Our ref: XA/2025/100424/04-L01
Your ref: EN010162
Date: 24 March 2026

ENVIRONMENT AGENCY RESPONSE DEADLINE 2 SUBMISSIONS.

GREAT NORTH ROAD SOLAR AND BIODIVERSITY PARK

1 % AEP + 30 % CC and
+ 39 % CC scenarios
Figure A9.19

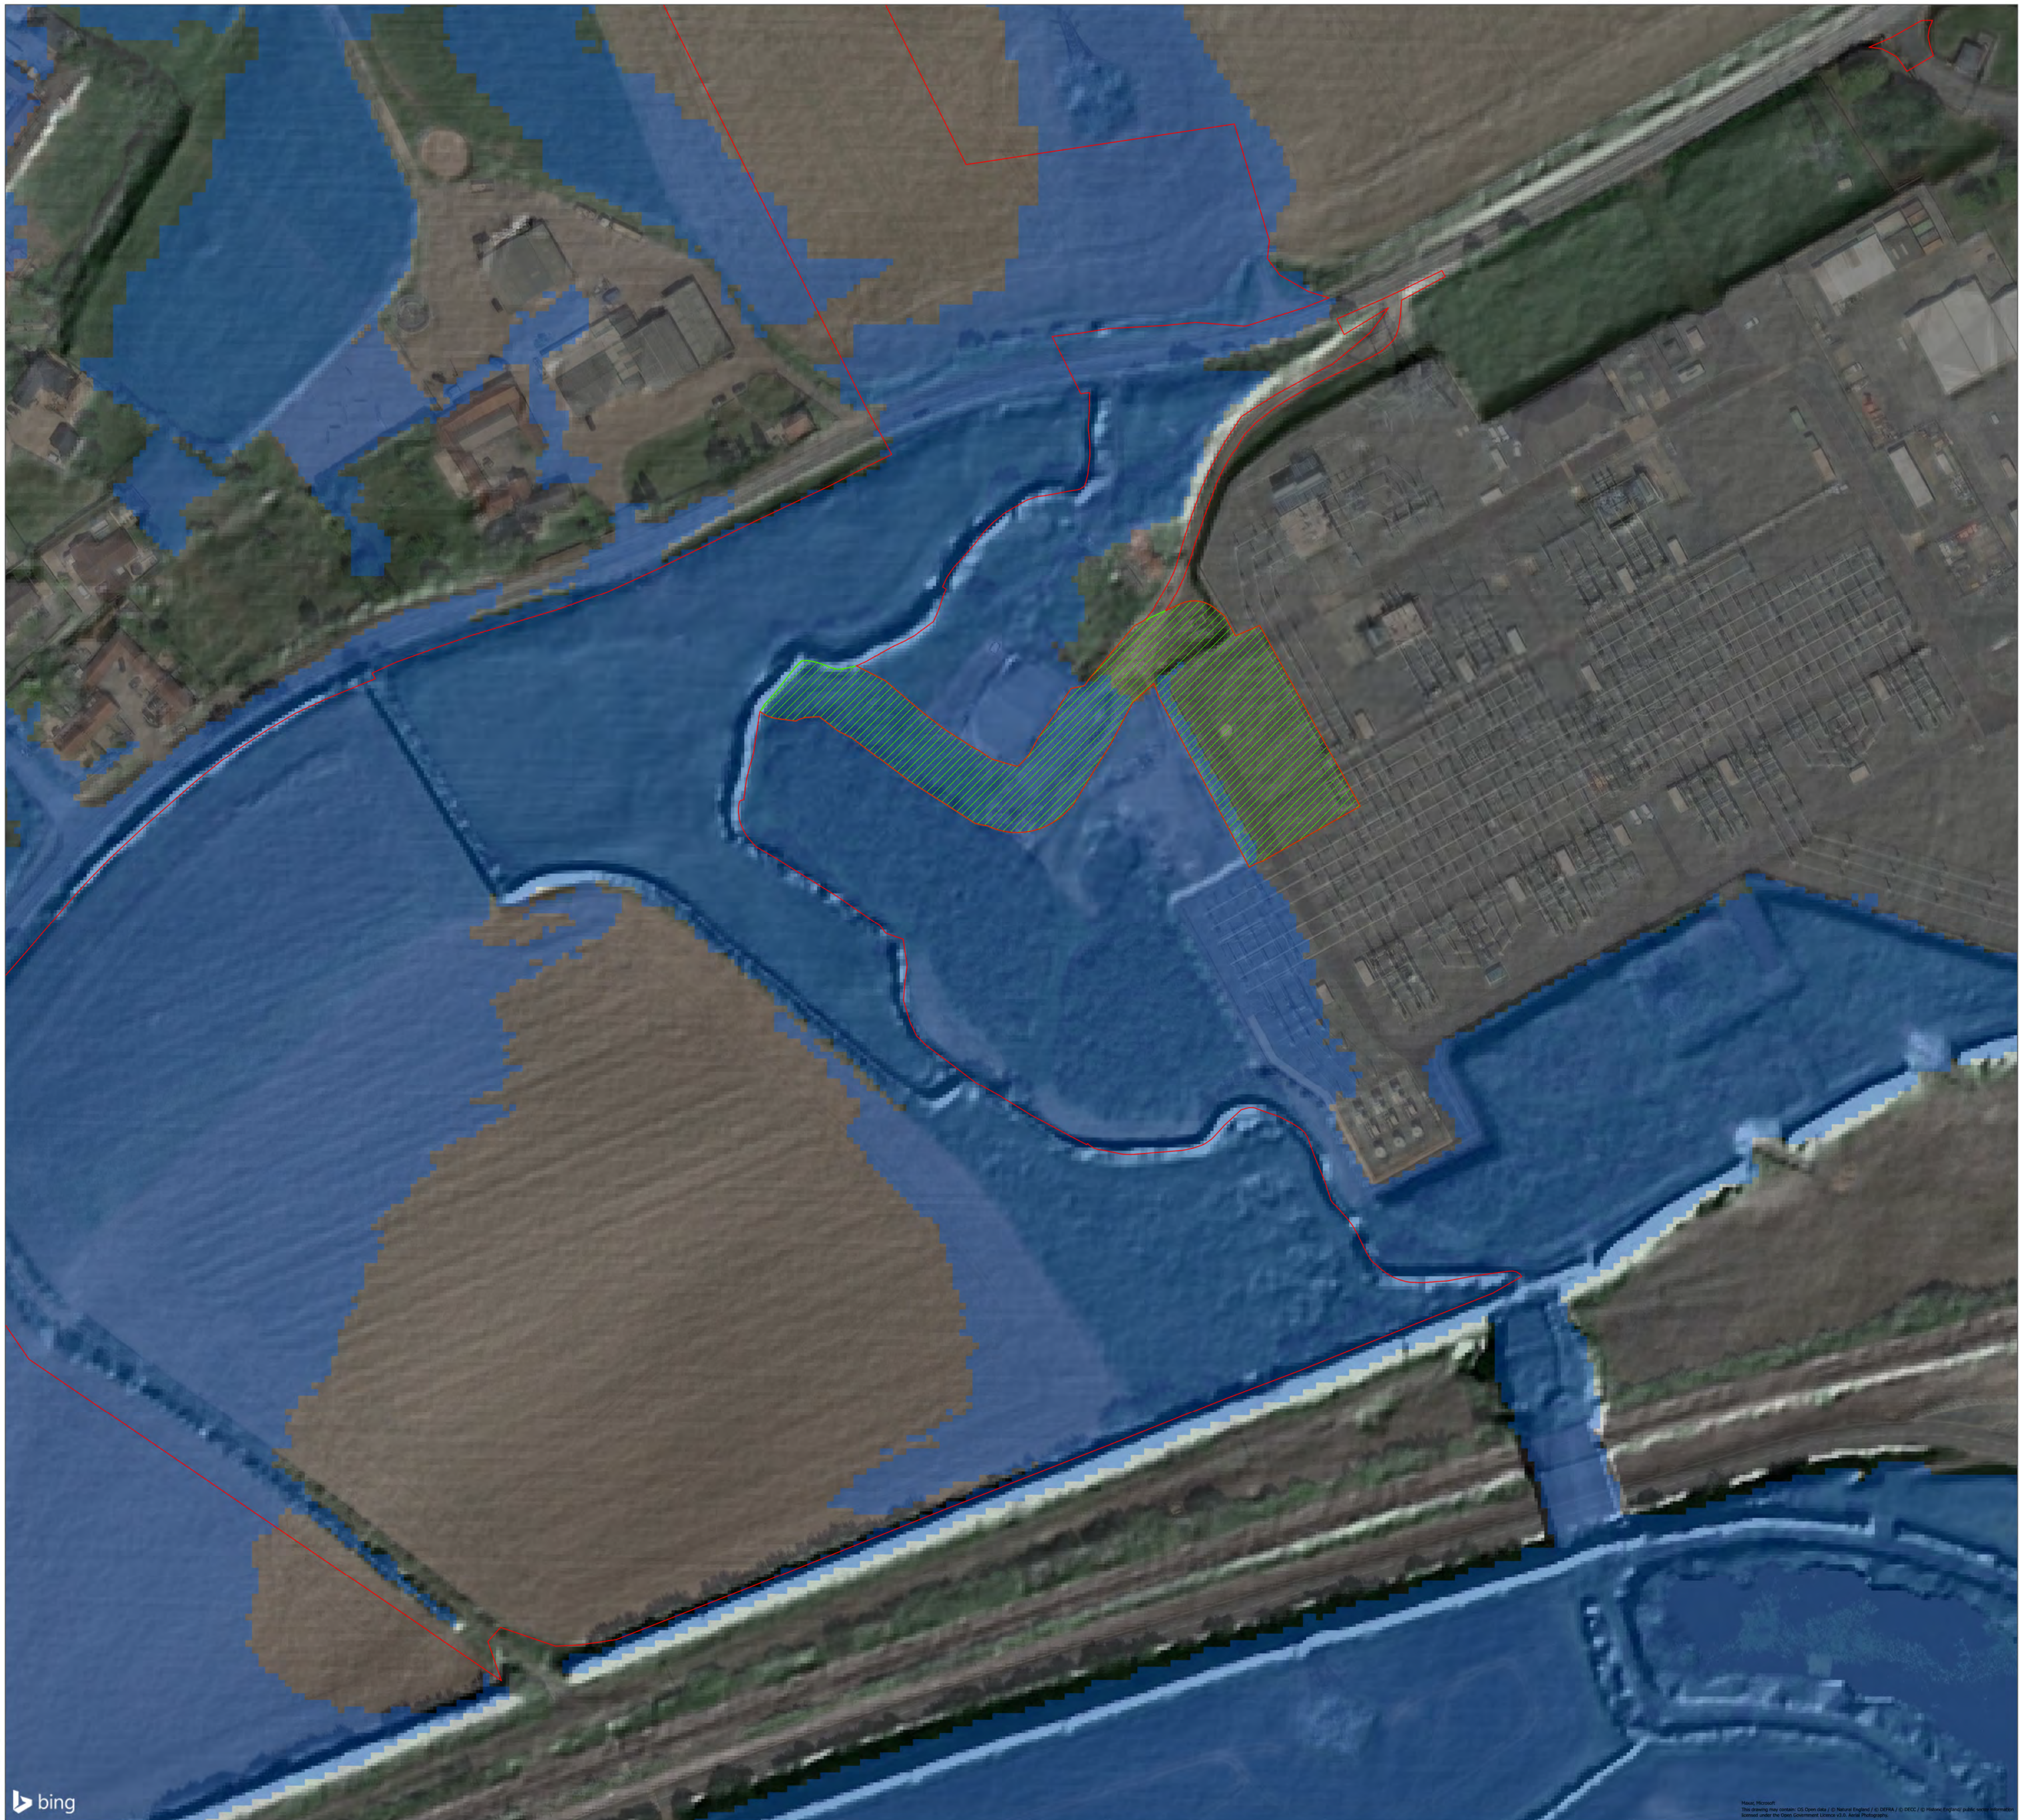
We were concerned that there was contradictory information within figure 9.18 of the Response to Section 51 following Acceptance - 6.4.9.1A Environmental Statement Volume 4 – Technical Appendices Technical Appendix A9.1 – Flood Risk Assessment (Clean) - Rev 2 [AS-051]. The Applicant referred to Figure 9.18 to show that all panels would be placed outside of the design event. However, this figure was named '1% AEP Defended Extents (CCP1)'. It was unclear whether the extent shown in this figure included the addition of 39% for the allowance of climate change.

This was a reporting issue, rather than an issue that is likely to alter the conclusions of the Flood Risk Assessment (FRA). The Applicant has expanded on the usage of the CCP1 (climate change projection 1) dataset within the 6.4.9.1C Environmental Statement Volume 4, Technical Appendices - Technical Appendix A9.1 – Flood Risk Assessment (Tracked) - Rev 4 [REP3-051], which we find to be reasonable. We are therefore content to resolve this issue.
